Rezoning Transportation Analysis

Petition Number: 2022-121

From: Jake Carpenter, PE
Jacob.carpenter@charlottenc.gov
980-221-5675

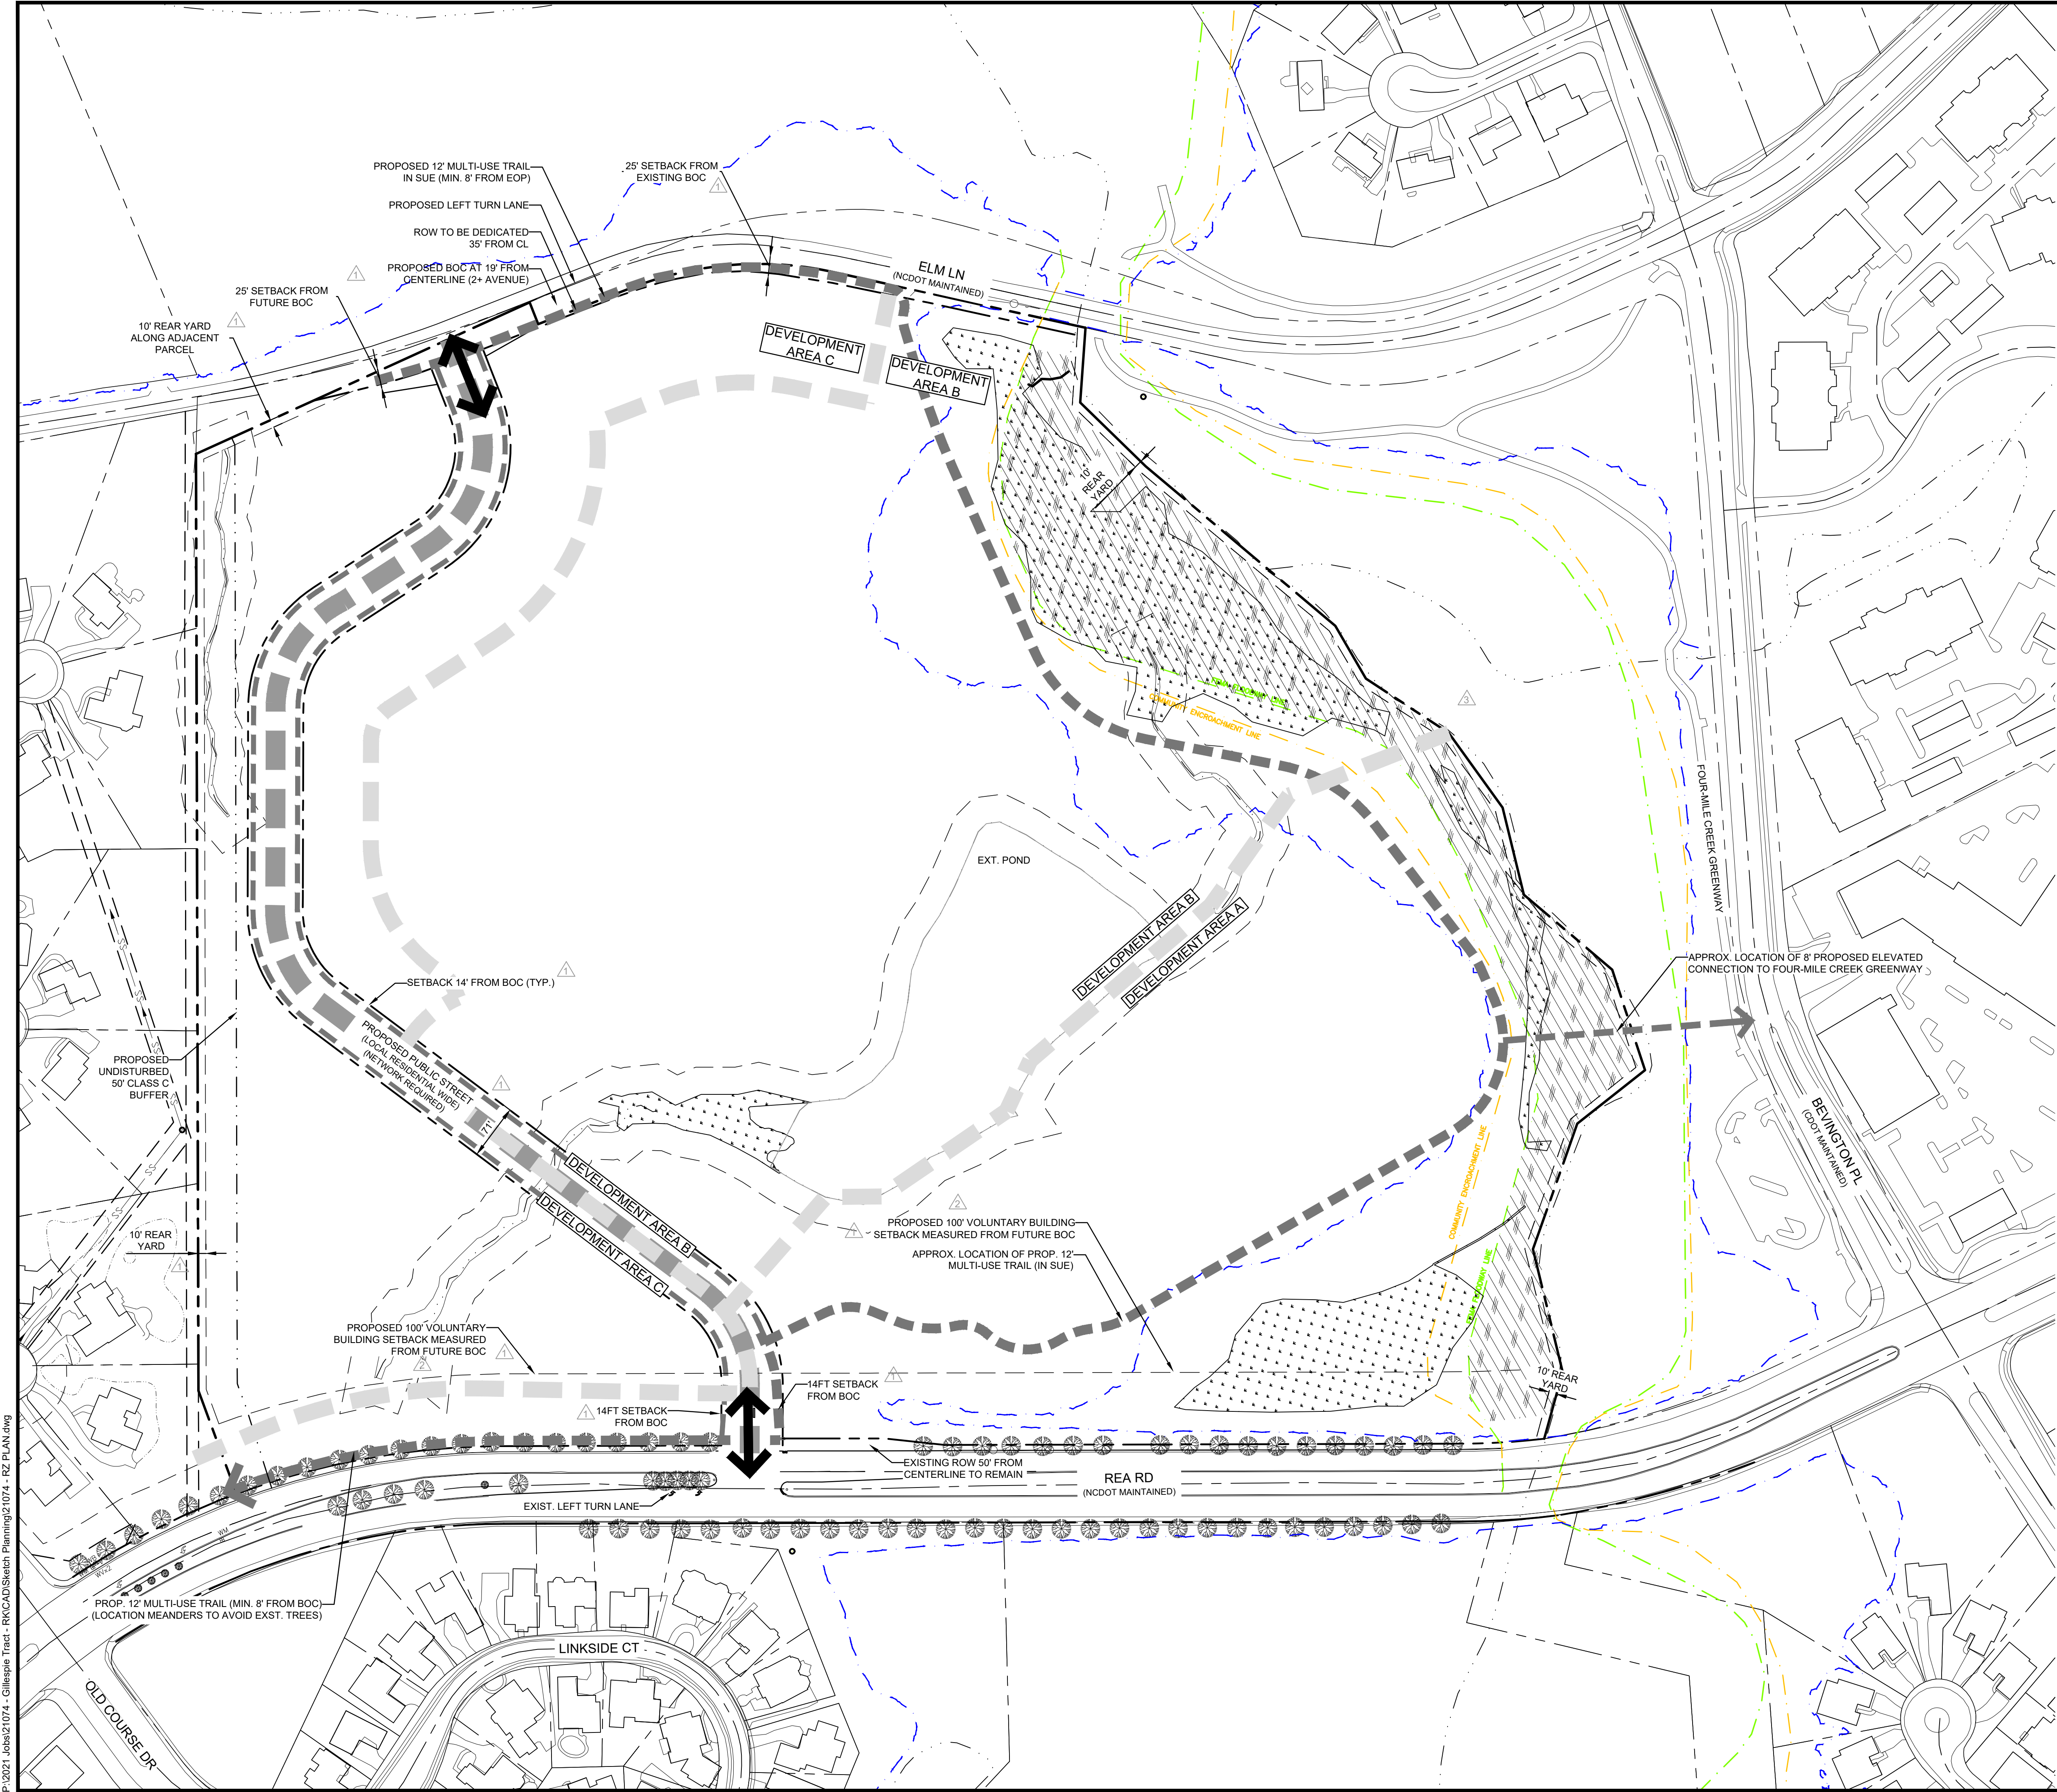
~~3. Revise site plan and conditional note(s) to commit to construct bicycle facilities by installing a 12' multi-use path along Rea Road to meet the Council-adopted Charlotte BIKES Policy. Multi-use paths maintained by the City shall meet ADA/PROWAG requirements. The multi-use path should provide a public onsite connection to the greenway. In addition, commit to providing public access easements~~

for the onsite MUP connections along Rea Road and Elm Lane. For multi-use paths along the public streets, provide sidewalk utility easement located 2ft at back of path if located outside of the right-of-way. Reconcile these improvements with conditional note 6.C

~~Clarifying Comment from 2/22/2023: Show MUP along Rea Road as shown above. We can work through the technical aspects in permitting as well as any necessary adjustments or exceptions to the required path.~~

~~Update Comment from 8/23/2023: MUP needs to follow Rea Road for a greater distance. Engineering documentation needs to be provided to allow the required streetscape (MUP) to be constructed onsite.~~

C. In lieu of the installation of an 8 foot wide planting strip and a 12 foot wide multi-use path along portions of the Site's frontages on Rea Road and Elm Lane, Petitioner shall install a 12 foot wide multi-use path within the Site that will traverse the Site from the new internal public street to Elm Lane as generally depicted on Sheet RZ-2 of the Rezoning Plan. This 12 foot wide multi-use path shall be located in a sidewalk utility easement. This 12 foot wide multi-use path shall be installed prior to the issuance of a certificate of occupancy for the 300th multi-family dwelling unit constructed on the Site.
